Architectural Liaison Officer

To: Farzana Tabasum Investment & Regeneration Service Kirklees Council Civic Centre 1, Huddersfield, HD1 2EY	Ref: 2016/62/91573/W Date: 4 th October 2016
---	--

**Cellars Clough Mill, Manchester Road, Marsden
Demolition of mill and erection of 55 dwellings with associated parking**

SITE LAYOUT APRIL 2016

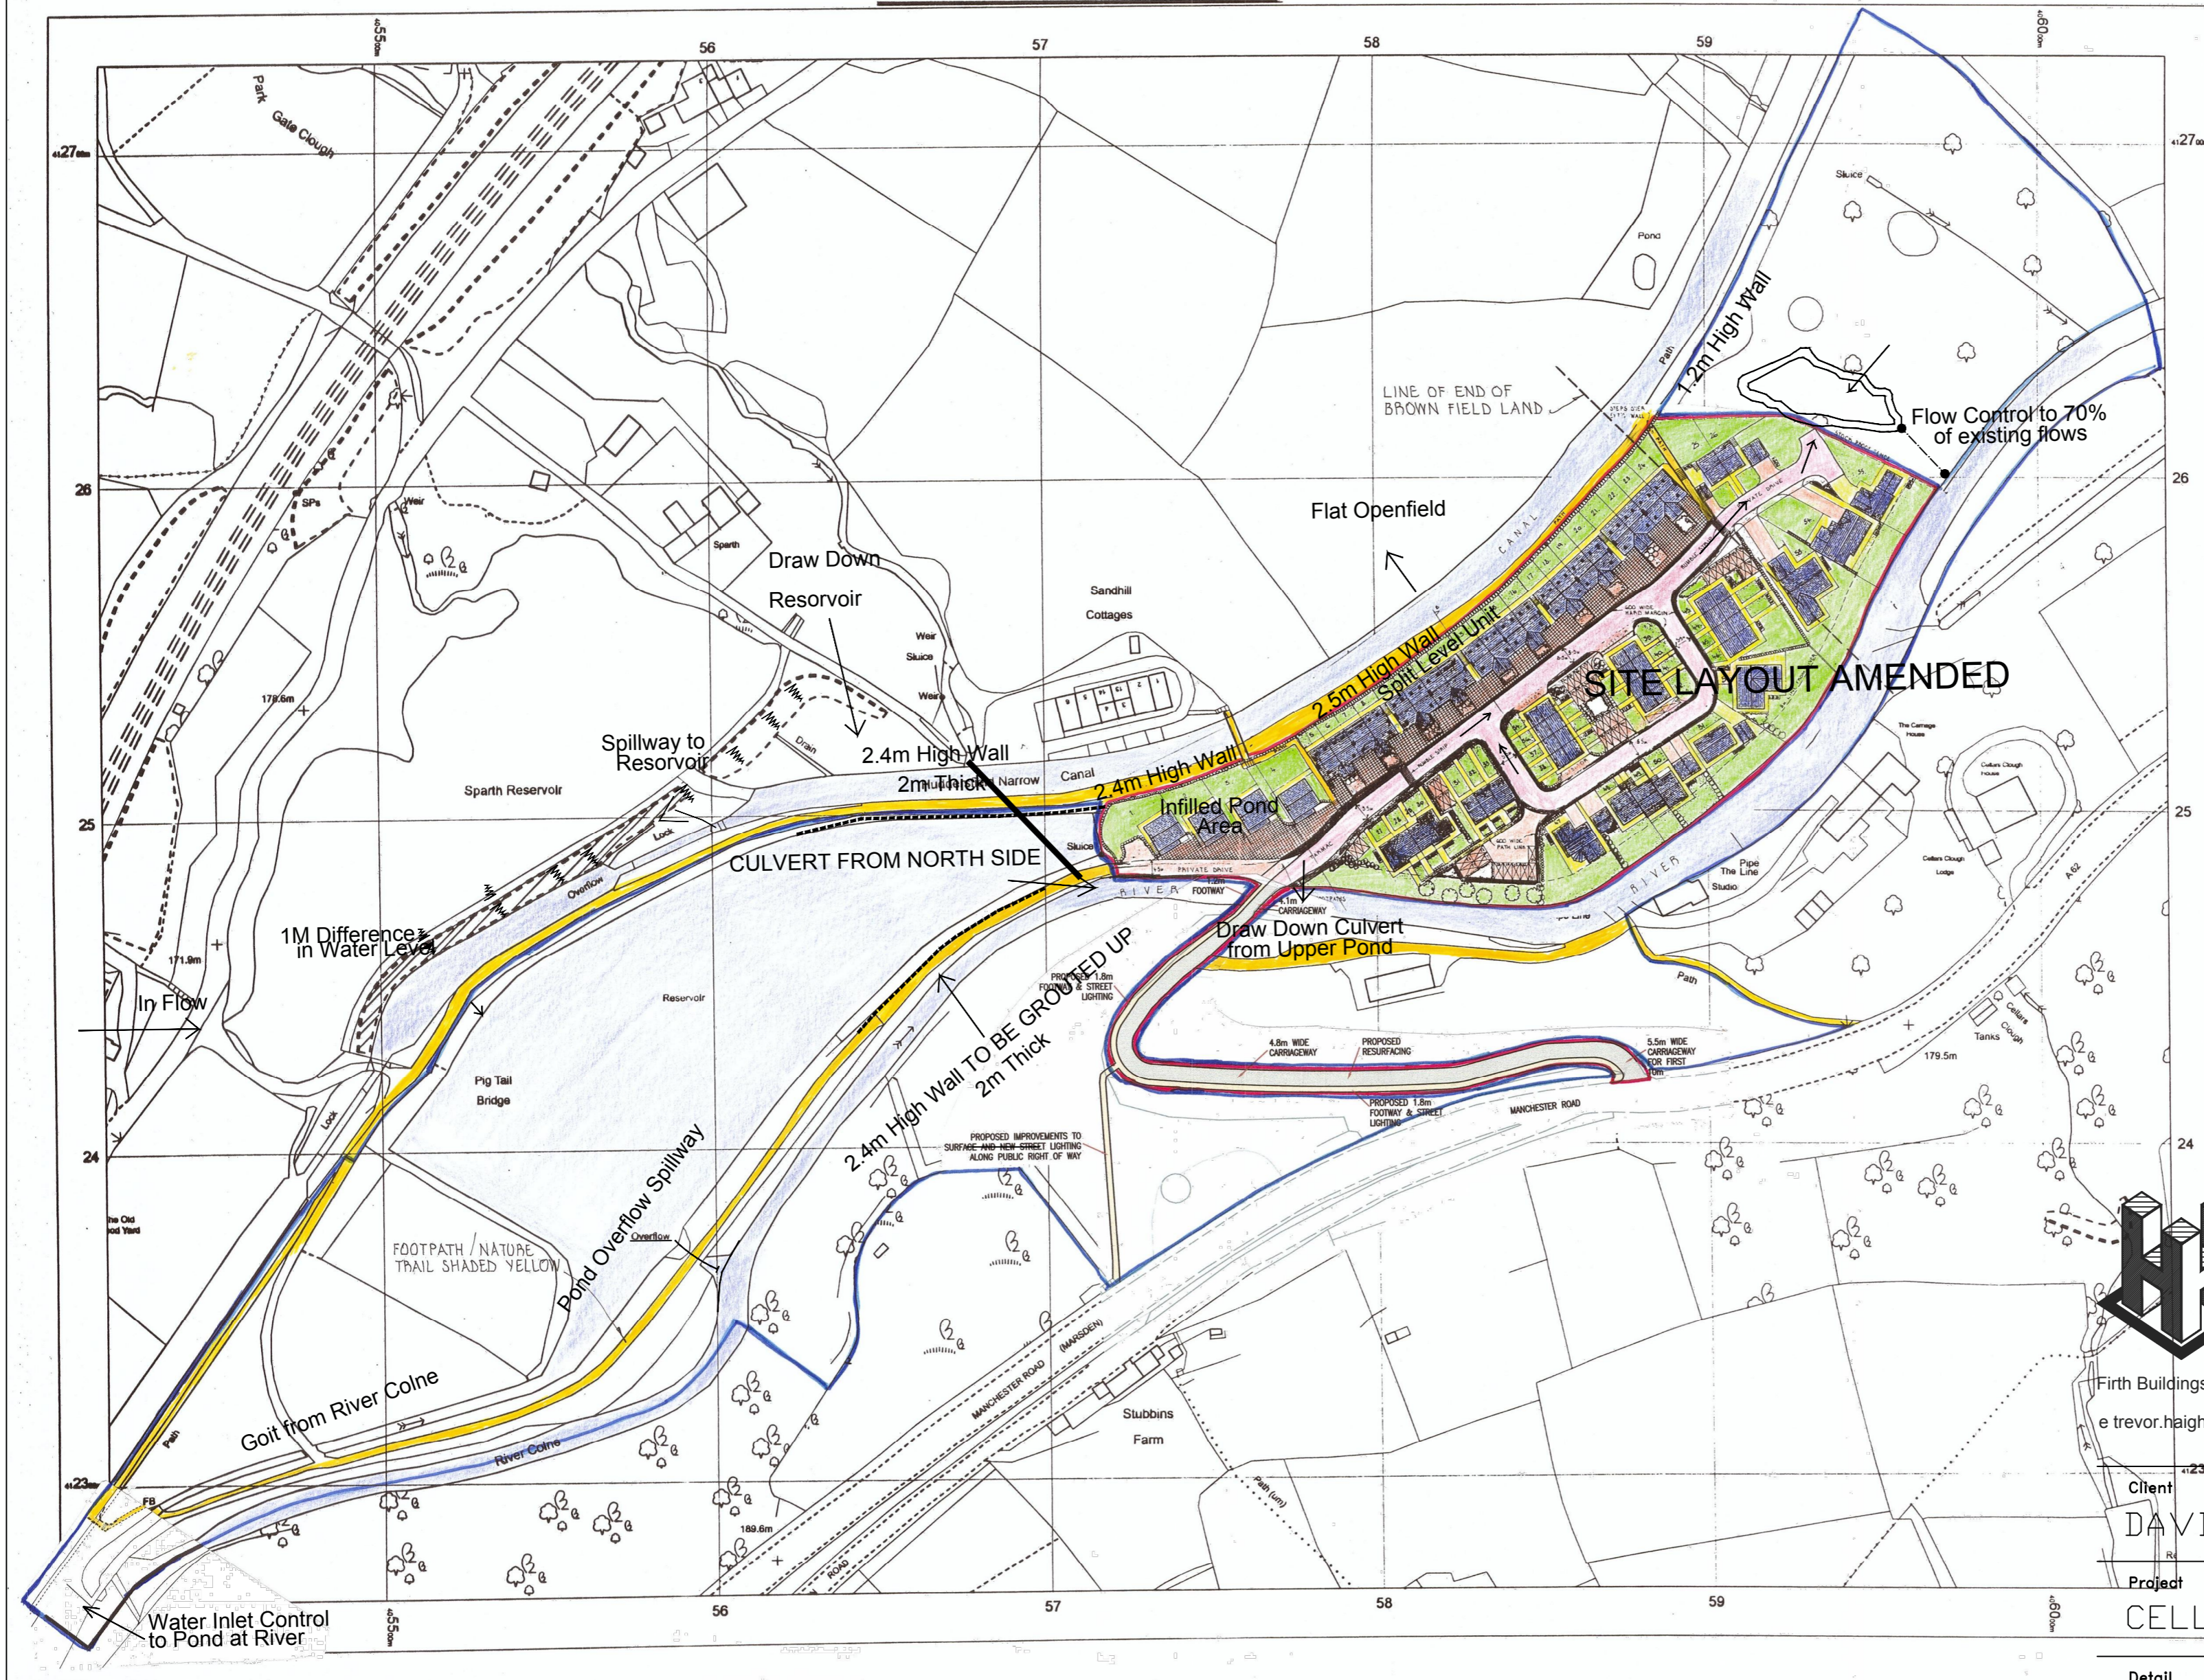
Footpath running along the rear of plots 5-24

Is this a continuous path that runs alongside the windows of the entire row of houses? If so, residents would have no defensible space. There would be no privacy for residents and the potential for nuisance and conflict.

In addition, during periods when residents wish to have those windows open, their homes would be at risk of burglary, given the proximity of the path to the windows.

A redesign would be required, giving residents an adequate amount of private, defensible space around their homes.

Hidden, remote parking spaces

There are several areas where parking spaces appear to be remote from their 'allocated' homes, and hidden from adequate surveillance, by tall garden boundary fences / blank gable elevations.

At the very least, car parking spaces need to be within view from the car owner's home. Residents will resort to parking on the land in front of their home if the 'designated' spaces are out of sight or considered too remote.

Parking spaces between 34-38 & 39-42

The compact parking arrangement here is likely to be a recipe for conflict. The closeness of the spaces will inevitably result in accusations of cars 'taking two spaces up'. There will be a high risk of vehicles being damaged. Residents will resort to parking on land directly adjacent to, or in front of, their homes.

Plot 4. Protection from footpath.

The rear of plot 4 is vulnerable to crime / nuisance because of the footpath running alongside. What boundary treatment provision would there be to protect this house from crime / anti-social behaviour / fear of crime?
